My reference: 3/2024/0107  
Direct Dial: (01200) 425111  
[www.ribblevalley.gov.uk](http://www.ribblevalley.gov.uk)  
Email: [planning@ribblevalley.gov.uk](mailto:planning@ribblevalley.gov.uk)  
Date: 21 June 2024

Location: Talbot Hotel 5 Talbot Street Chipping PR3 2QE

Proposal: Approval of details reserved by conditions 3 (walling and roofing materials), 4 (window and door specifications), 5 (rainwater goods and stonework repairs), 8 (construction management statement) and 12 (boundary treatment) in respect of the former Talbot Hotel/Pub phase of Listed Building Consent 3/2023/0086.

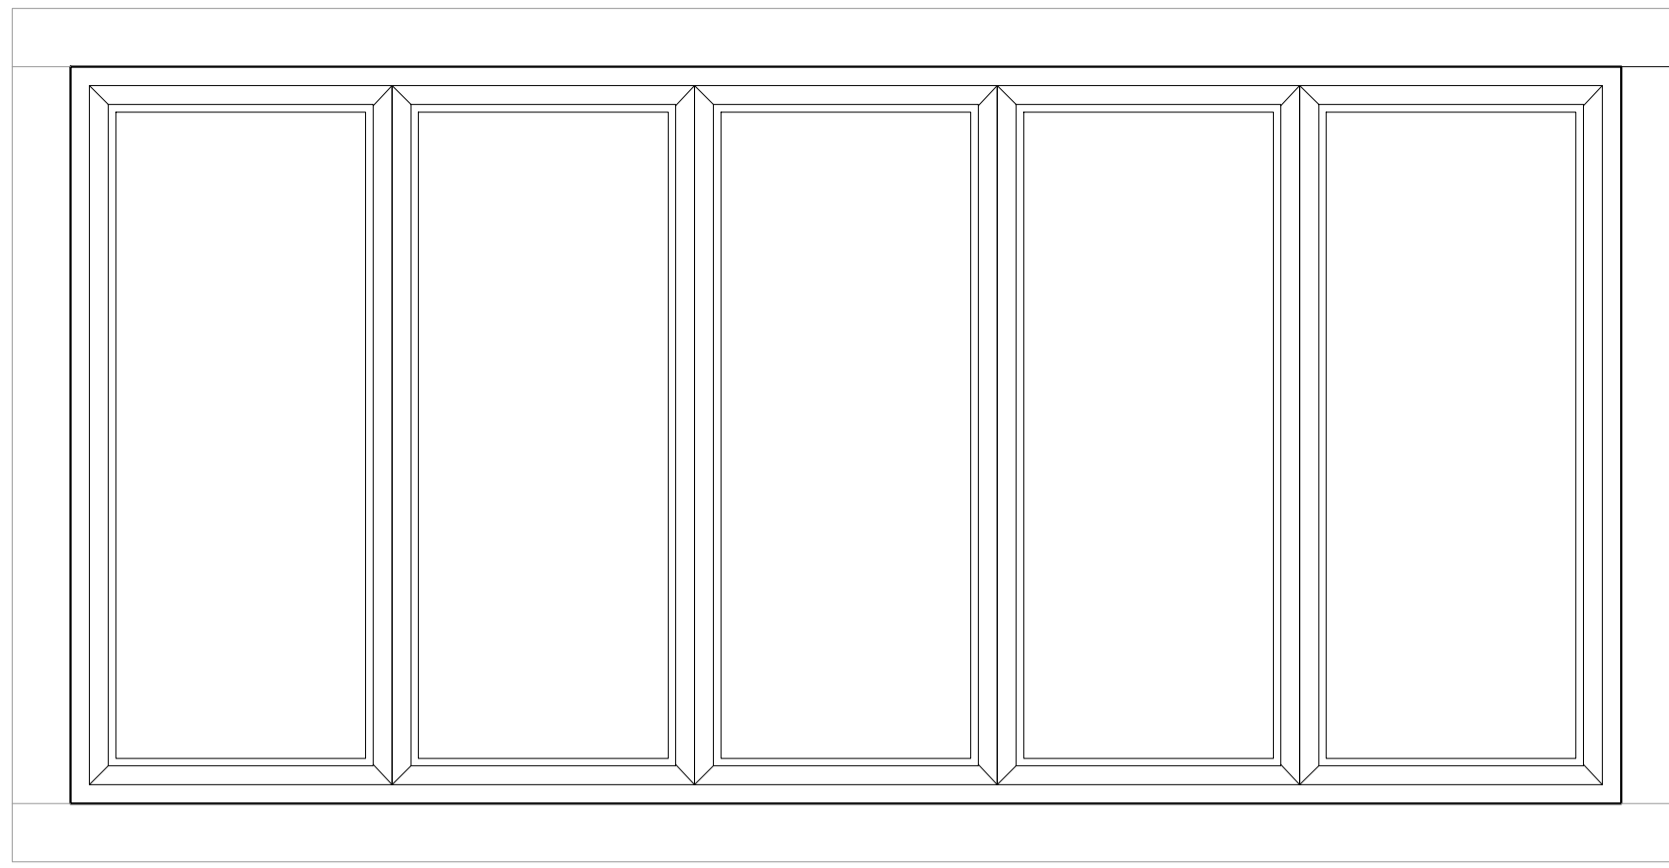
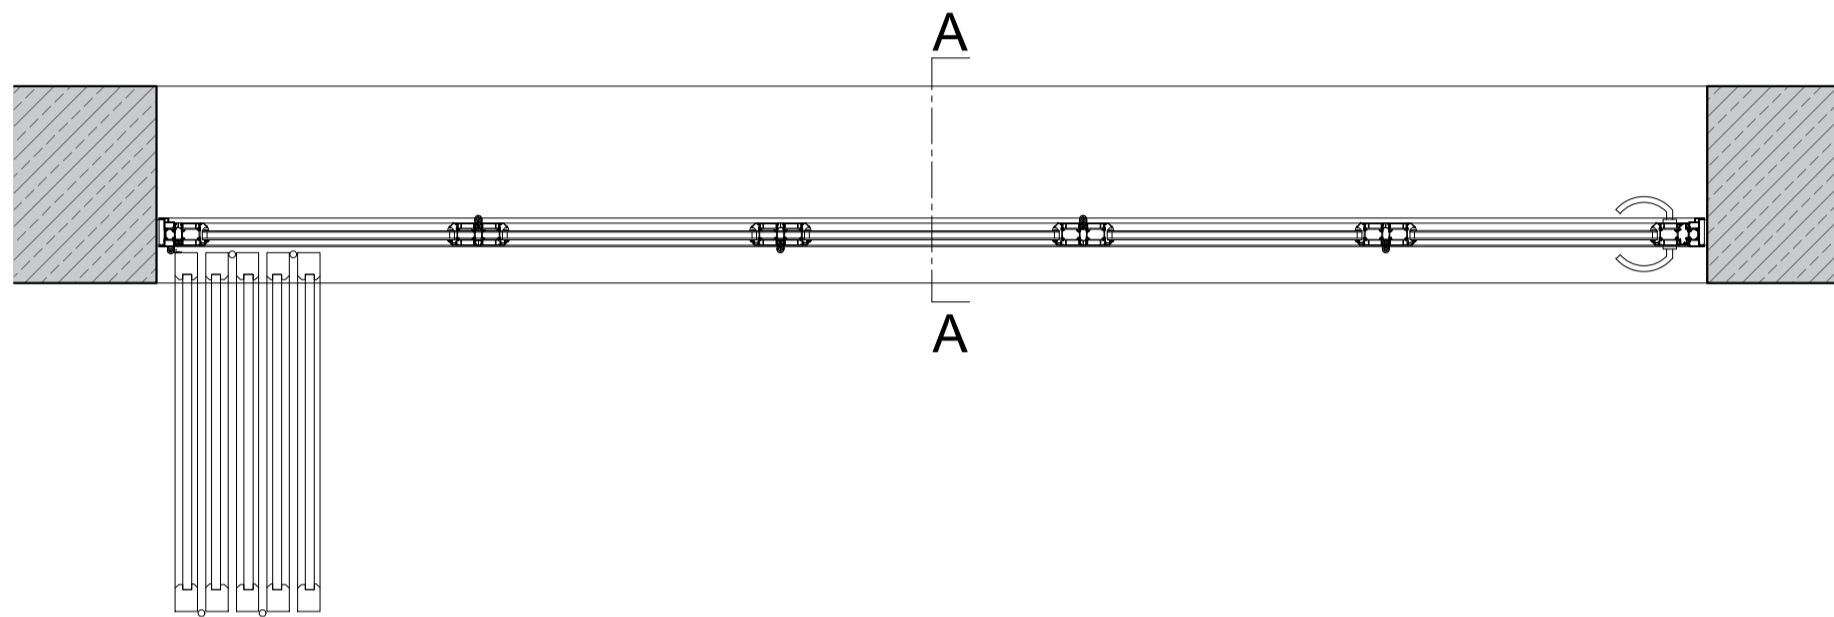
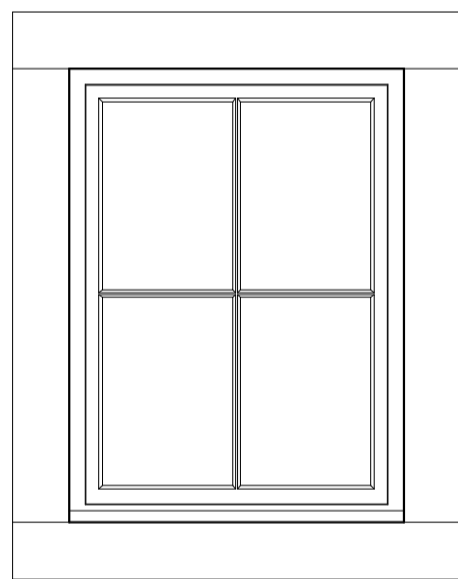
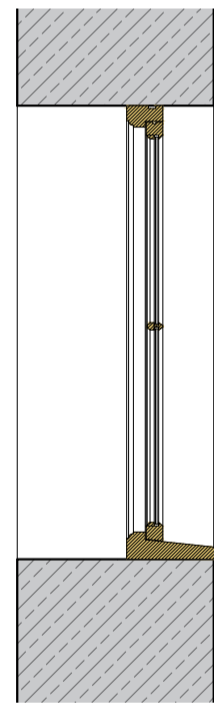
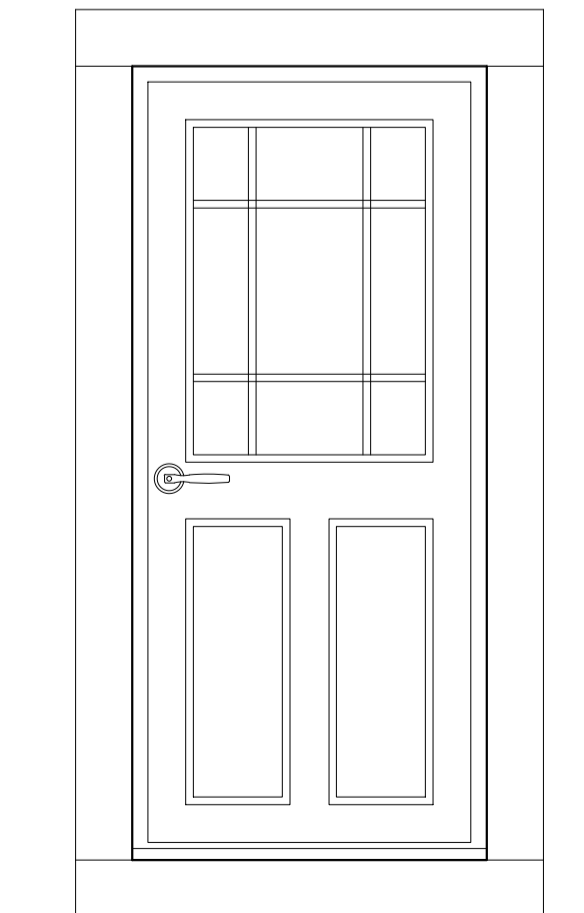
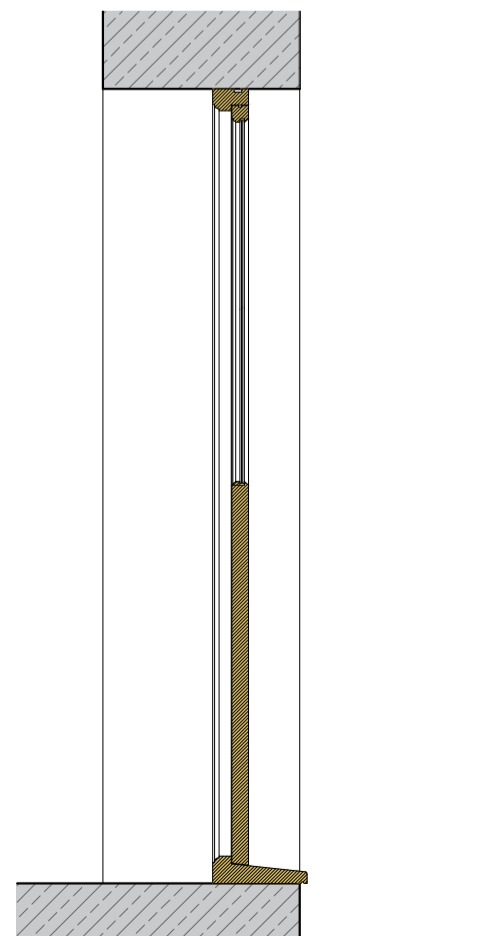
- 'Details of window and door repair/replacement' document (updated version received 19/4/24) and 'Proposals for Repair' document together with drawing SPA Drawing 6521 DOC3. These confirm the use of Sapele timber, all window to be painted White and details of the locks and stays.

The development shall be carried out in accordance with the approved details and retained thereafter in order to satisfy the condition in full for the former Talbot Hotel phase.
